Re: Geologic Hazard Additional Borings
Springs at Waterview East (Trails at Aspen Ridge)
South Powers and Bradley Road
Colorado Springs, Colorado

A Soils, Geology and Geologic Hazard Study was prepared by Entech Engineering, Inc., Revised Date February 8, 2019, for the above referenced site. This letter is in response to the Colorado Geological Survey (CGS) review letter dated July 19, 2019, CGS Unique No. EP-18-0011_5 which is attached to this letter.

**Subject: Trails at Aspen Ridge PUDSP191 (previously reviewed as Springs East at Waterview SP-17-010)
El Paso County, CO; CGS Unique No. EP-18-0011 5**

GEC01  
SHEET 4 OF 8

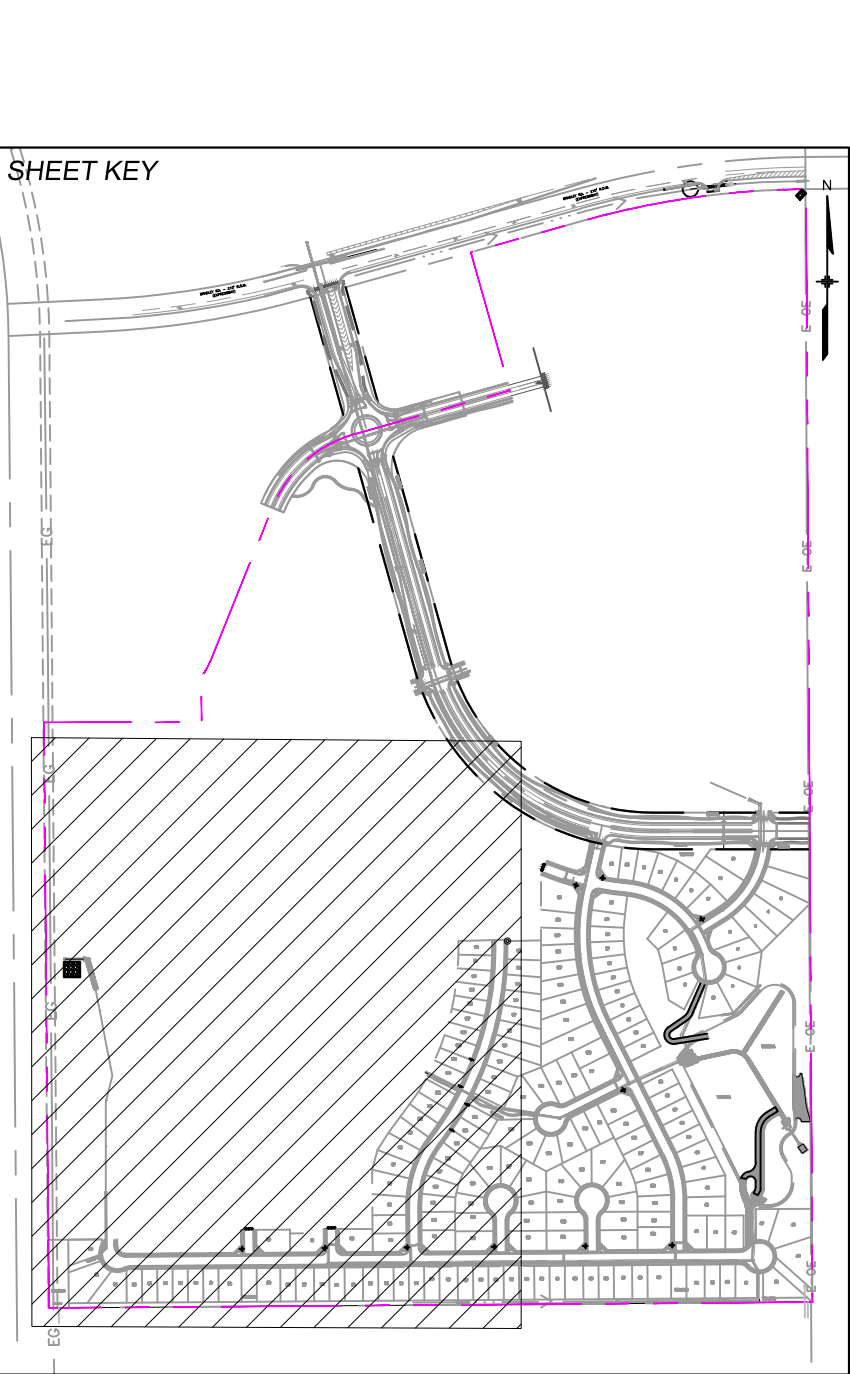
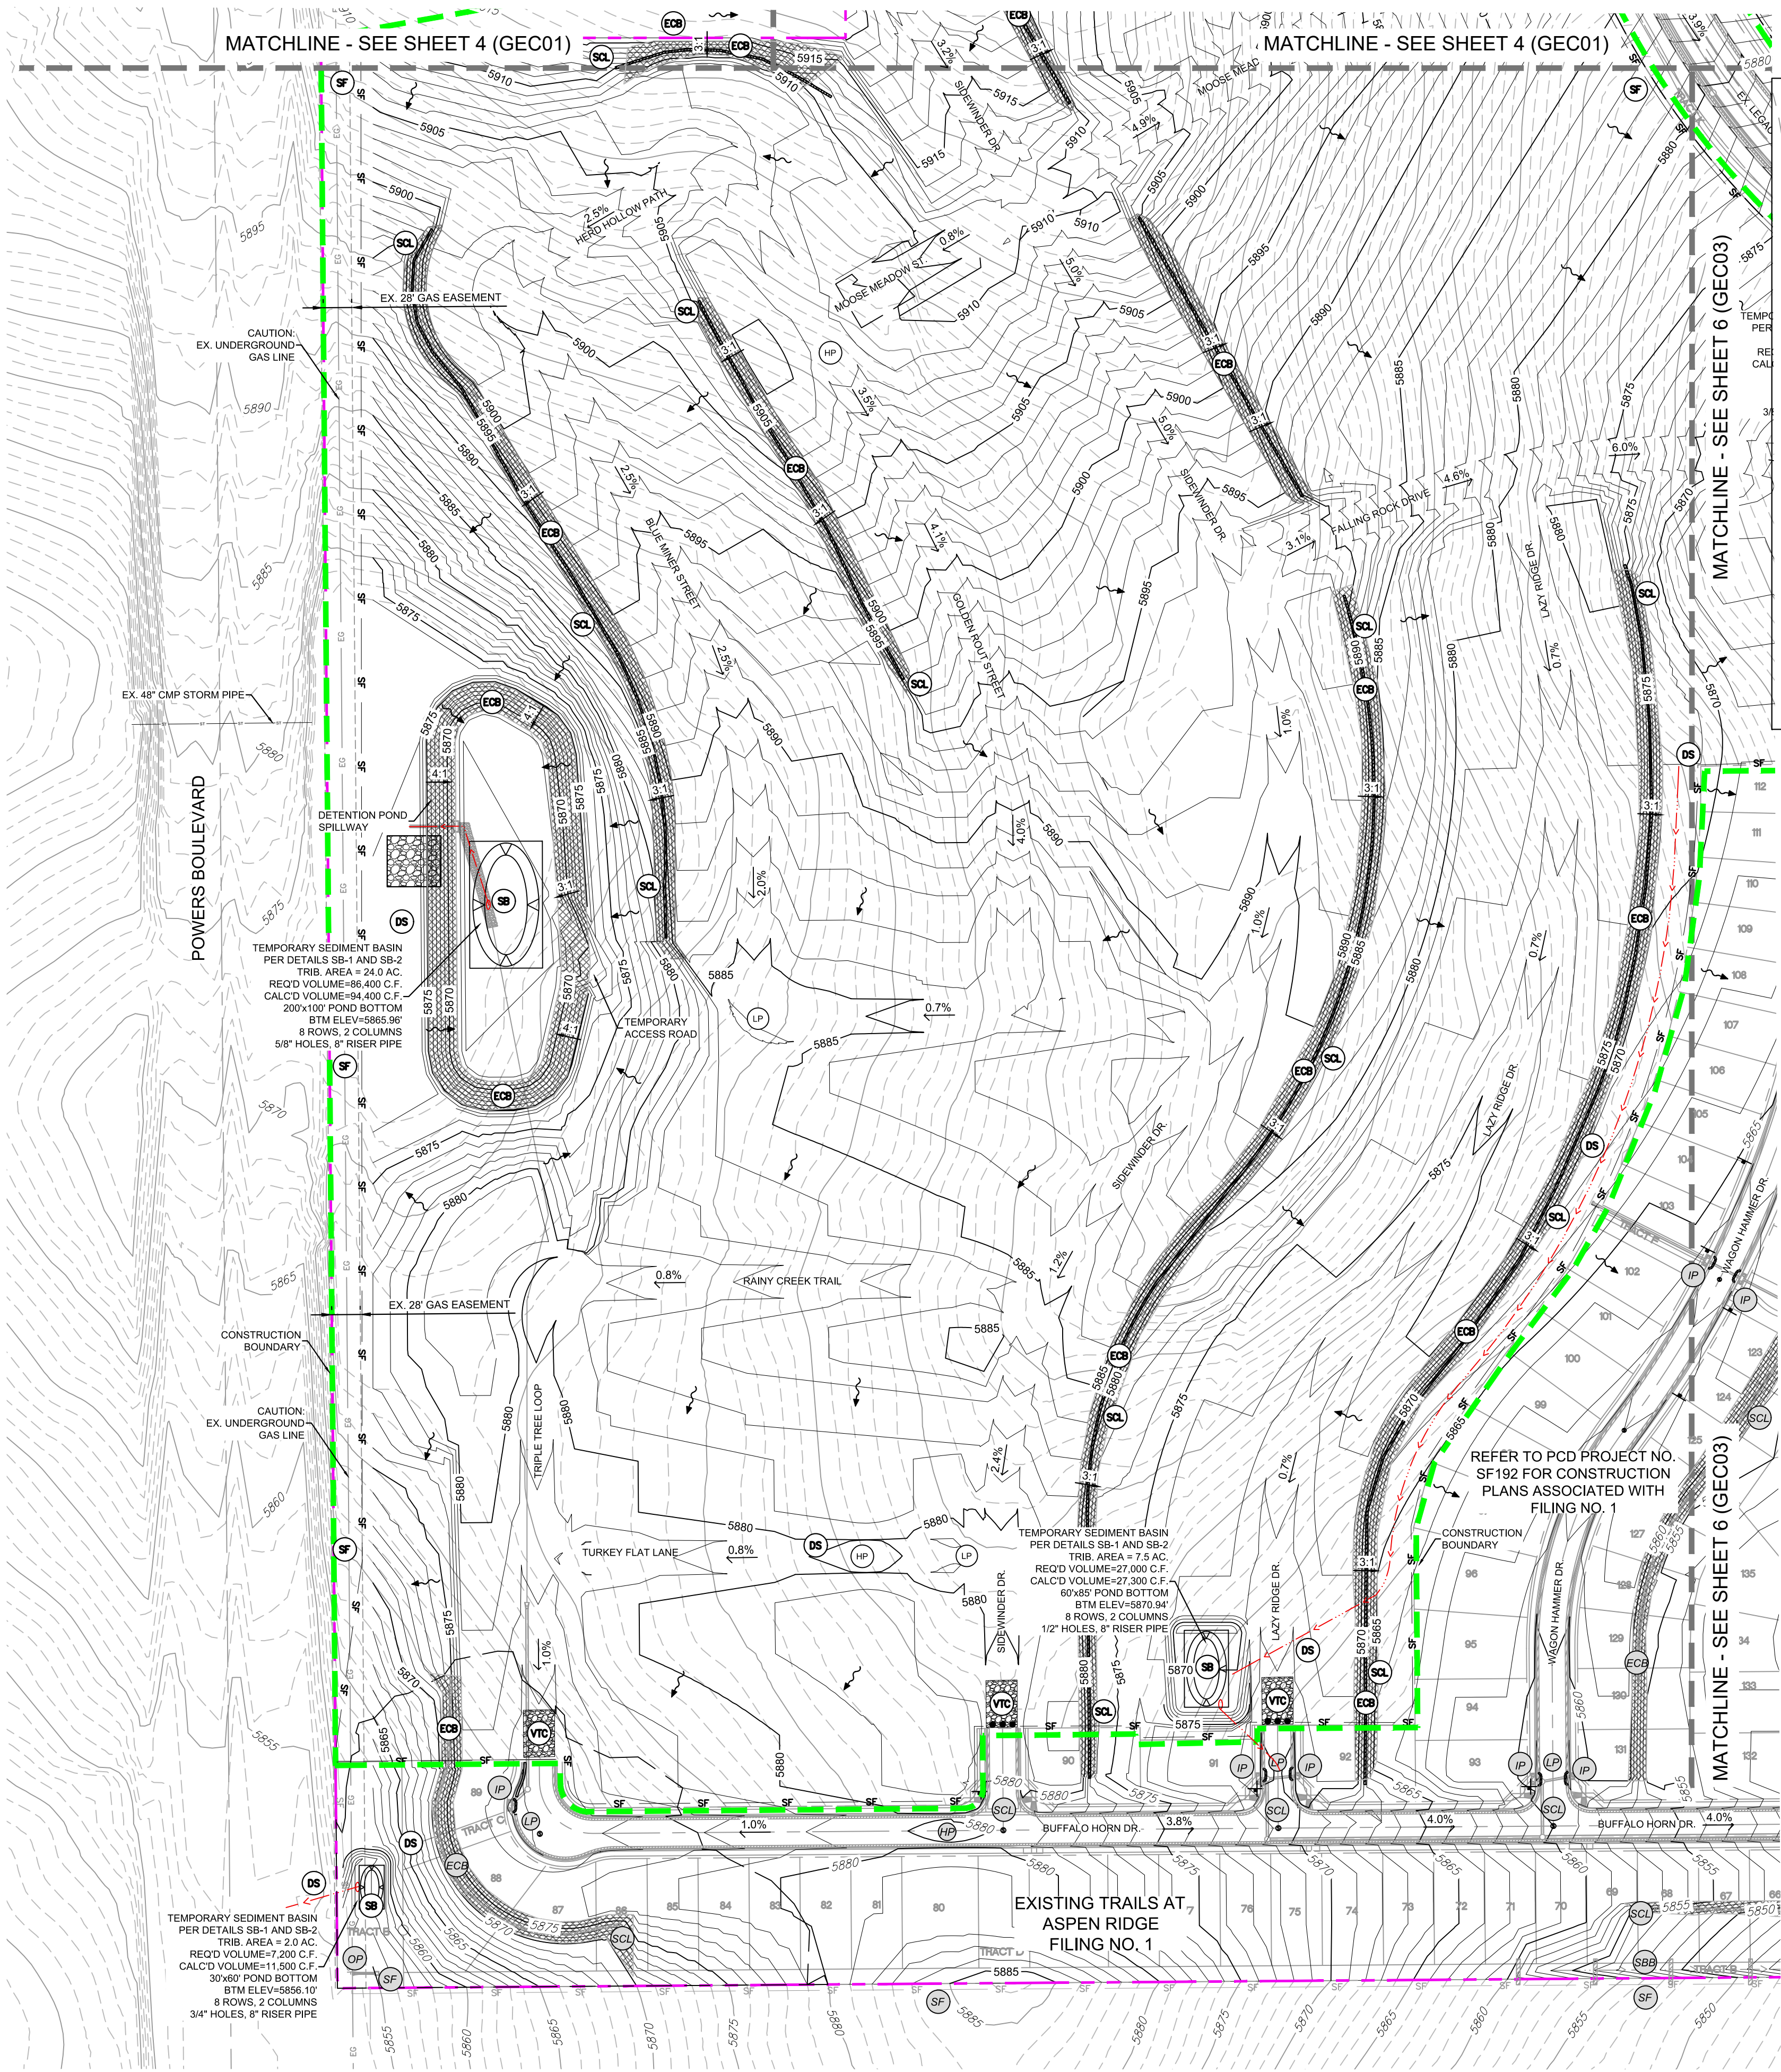
Entech's Appendix B boring TB-1 is located near the Legacy Drive/Frontside Drive cul de sac where, according to sheet 4 of the June 2019 Grading & Erosion Control Plans, approximately 10-15 feet of fill is proposed. TB-2 is located northwest of the Legacy/Frontside cul de sac, in a commercial area outside of the Trails at Aspen Ridge development area, described on sheet 4 of the grading plans as "unplatted."

CGS recommended additional investigation on the site in areas where significant cuts are proposed. Entech drilled four additional borings on August 7, 2019. Test Boring locations are shown on Figure 1. Test Boring Nos. 1 – 3 were drilled in areas of deep cuts, and Test Boring No. 4 was placed in an area of significant fill. Groundwater was not encountered during drilling or subsequent to drilling. The test borings were drilled to depths of 20 to 40 feet. Soils encountered in these borings consisted of predominantly sandy clay soils with underlying claystone and shale bedrock. The bedrock underlying the site is the Pierre Shale Formation of Cretaceous Age, which typically has a moderate to high expansion potential.

The new borings do not alter the conclusions in the previous reports. Based on the additional subsurface information, it is anticipated claystone or shale will be exposed in the majority of cuts proposed on the site. These soils have the potential for moderate to high expansion potential. Mitigation of the expansive soils will be required for the majority of the site. Specific recommendations for foundations and construction will be provided in the Subsurface Soil Investigations after additional site investigation is performed for the different phases of the development prior to construction.
